April 25, 2016

### RE: Riste Short Plat (SP-15-00007)

The Kittitas County Community Development Services Department has determined that the Riste Short Plat (SP-15-00007) is a complete application and hereby grants **preliminary approval**; final approval shall be subject to the following conditions:

DRAWING TYPE: SHORT PLAT APPLICATION

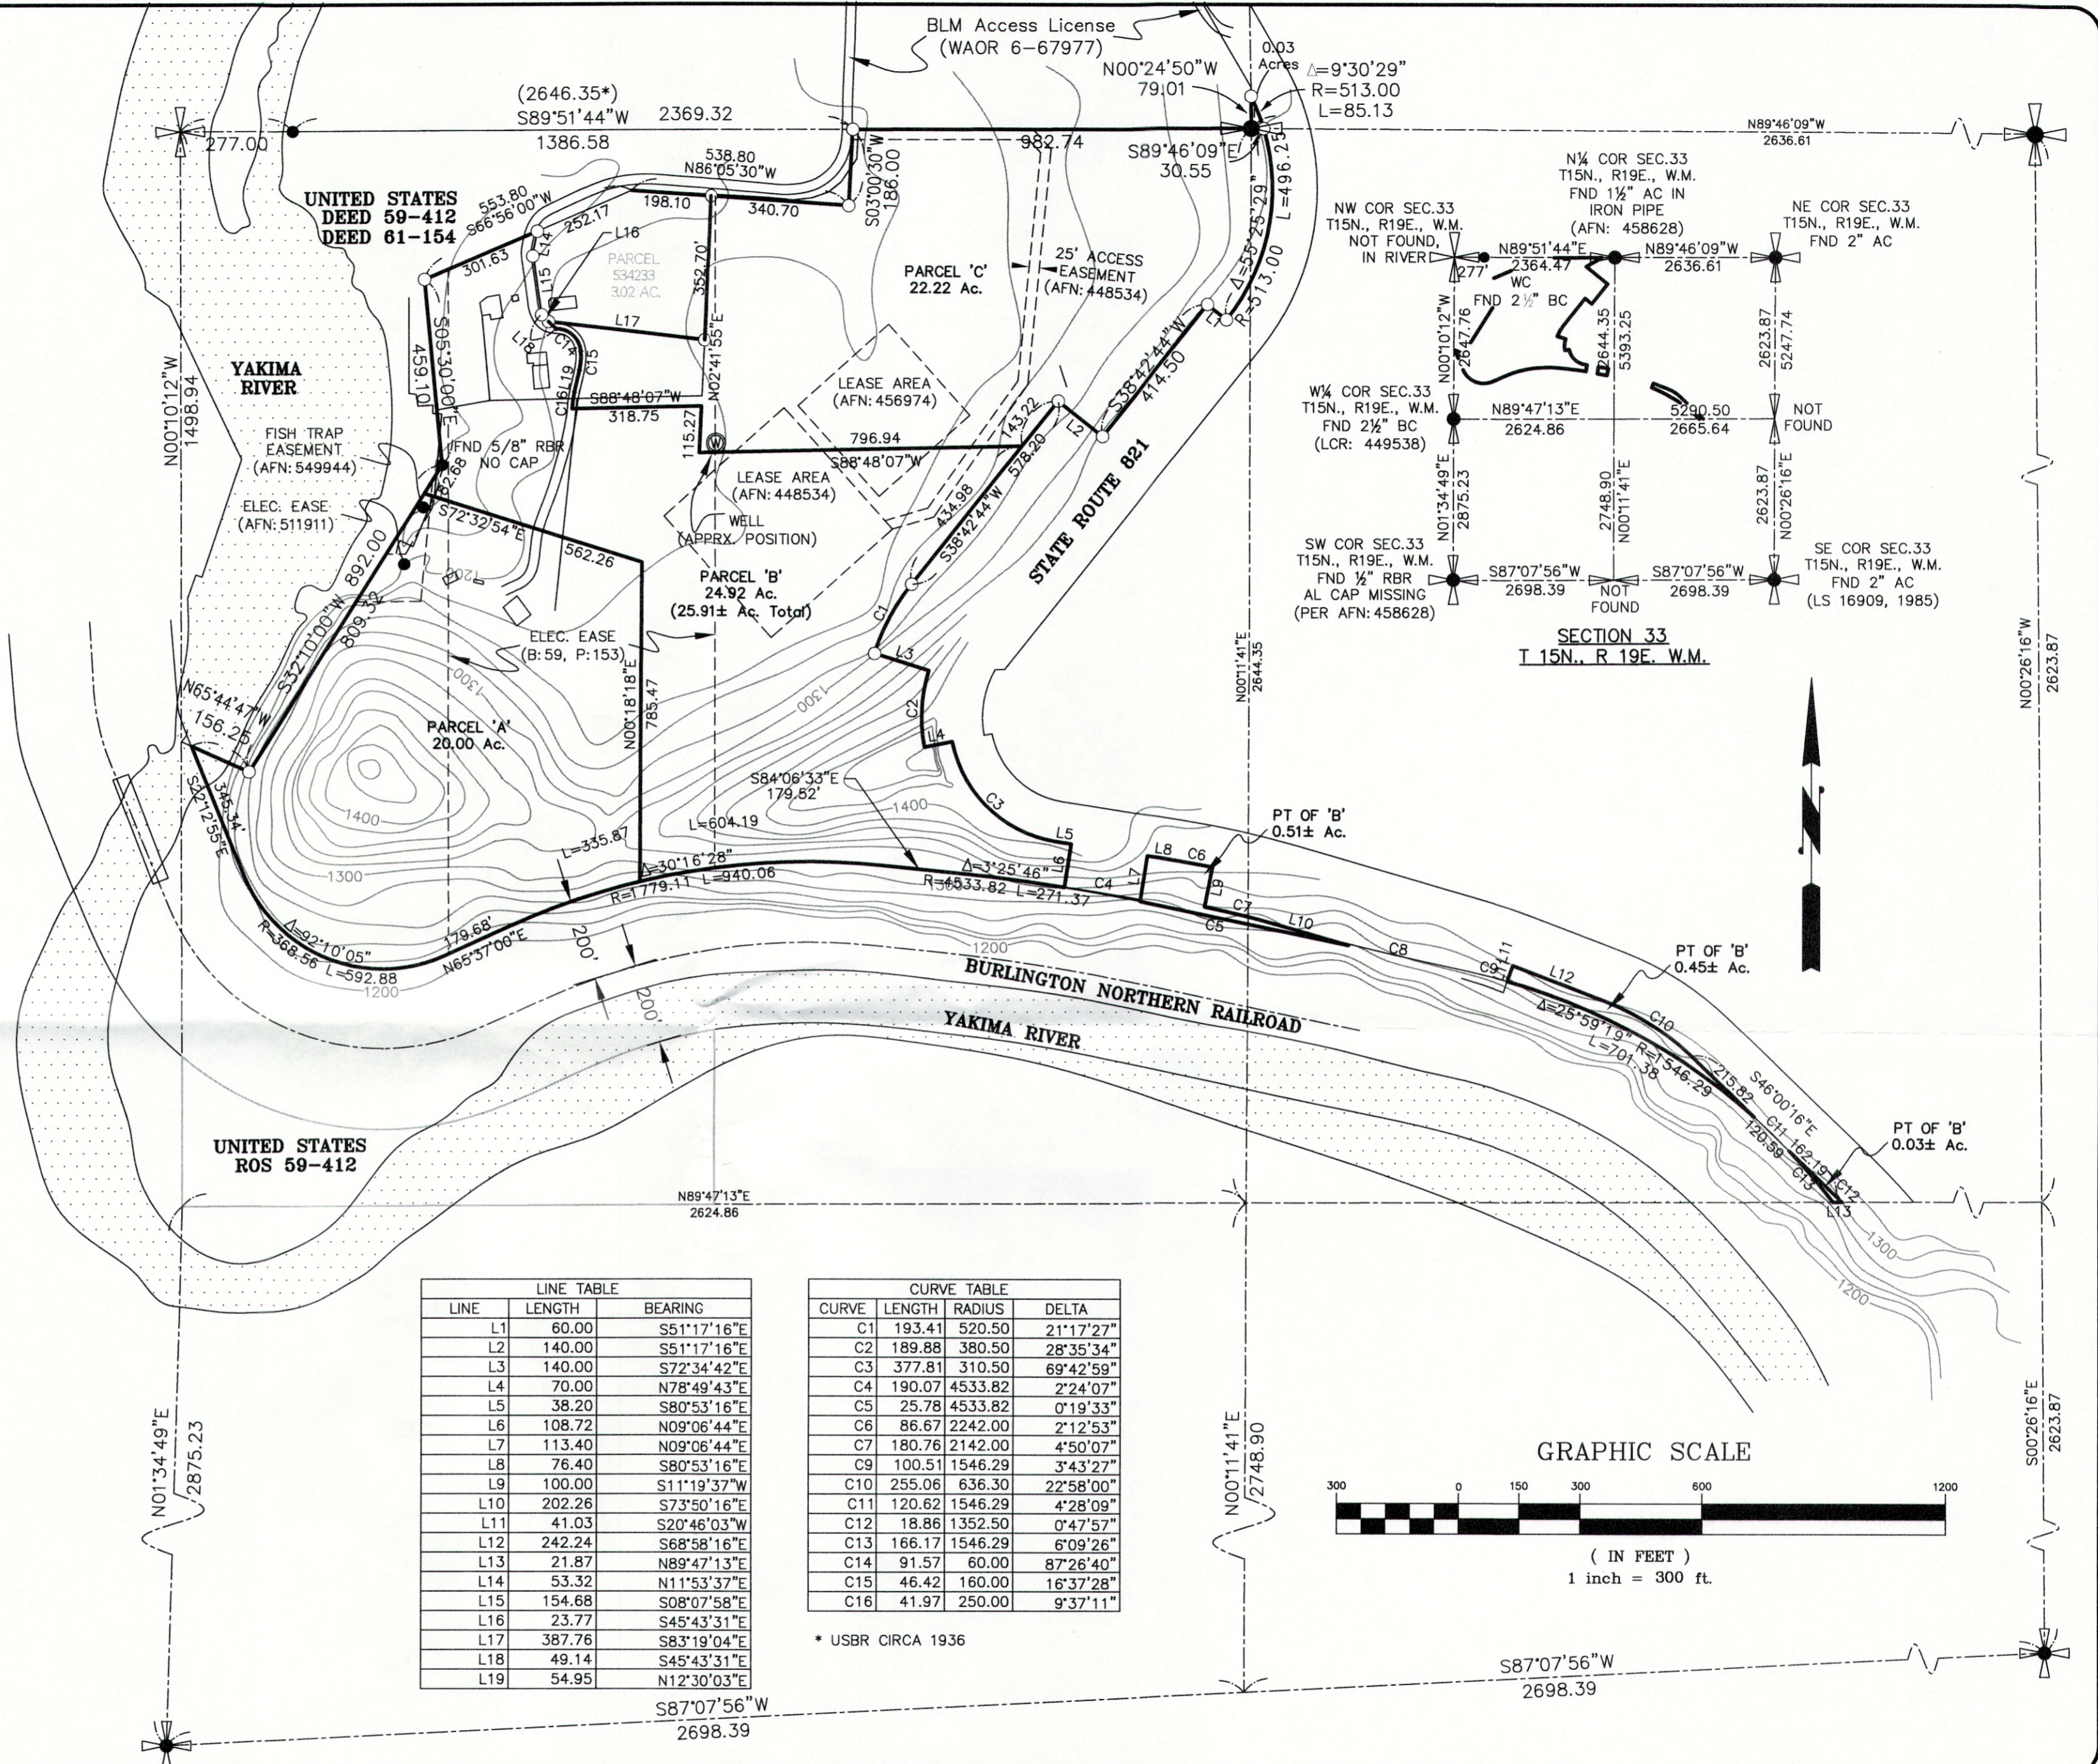
1. Both sheets of the final mylars shall reflect short plat number SP-15-00007 and an accurate legal description shall be shown on the face of the final plat. Engineers and Surveyors need to be cognizant of all of the requirements related to Final Plats (KCC 16.20) and Survey Data and Dedications (KCC 16.24). The final plat must be submitted in full conformance with these chapters of Kittitas County Code; **non-compliant mylars will be rejected and returned to the applicant.**

5. An access easement for Parcel "A" of the Riste Short Plat needs to be shown on the face of the short plat.
6. No driveway or road shall be constructed within five feet of the side yard boundary, unless the driveway or road is part of an easement shared with the neighboring property owner.

25. All future development must comply with International Fire Code (IFC) and appendices.
26. Parcel A and B of the Riste Short Plat may contain wetlands. The Final mylars shall reflect the location of these wetlands and a statement on the plat shall read as follows: "Future development of lots may require a study by a certified wetland biologist to determine wetland classification and for buffer requirements pursuant to KCC Critical Areas Code."

27. Parcel A and B of the Riste Short Plat may contain floodplain. The subject property contains areas designated on FEMA Flood Insurance Rate Map panel 5300950650B as having a 1 % or greater annual chance of flooding. Any development within these areas shall be subject to all applicable Federal, State, and County regulation. Kittitas County flood damage prevention code (KCC Chapter I 7 A.05; Ord. 93-18 by reference) requires any development within this area to obtain a permit. Flood insurance may be required for any structures on the subject properties.

28. County data indicates that portions of parcels A and B contain slopes of 33.3% or greater; the plat note shall be placed on the on the Riste short plat: The placement of buildings and structures on or adjacent to ascending or descending slopes steeper than 1 unit vertical in 3 units horizontal (33.3-percent slope) shall conform to the building setback requirements of current adopted building codes (IRC Section R403.1.7 and IBC Section 1805.3.1). Alternate setbacks and clearances are permitted, subject to the approval of the building official. The building official is permitted to require an investigation and recommendation of a qualified engineer to demonstrate the requirements necessary to construct a building on or adjacent to ascending or descending slopes. Such an investigation shall include consideration of material, height of slope, slope gradient, load intensity and erosion characteristics of slope material.
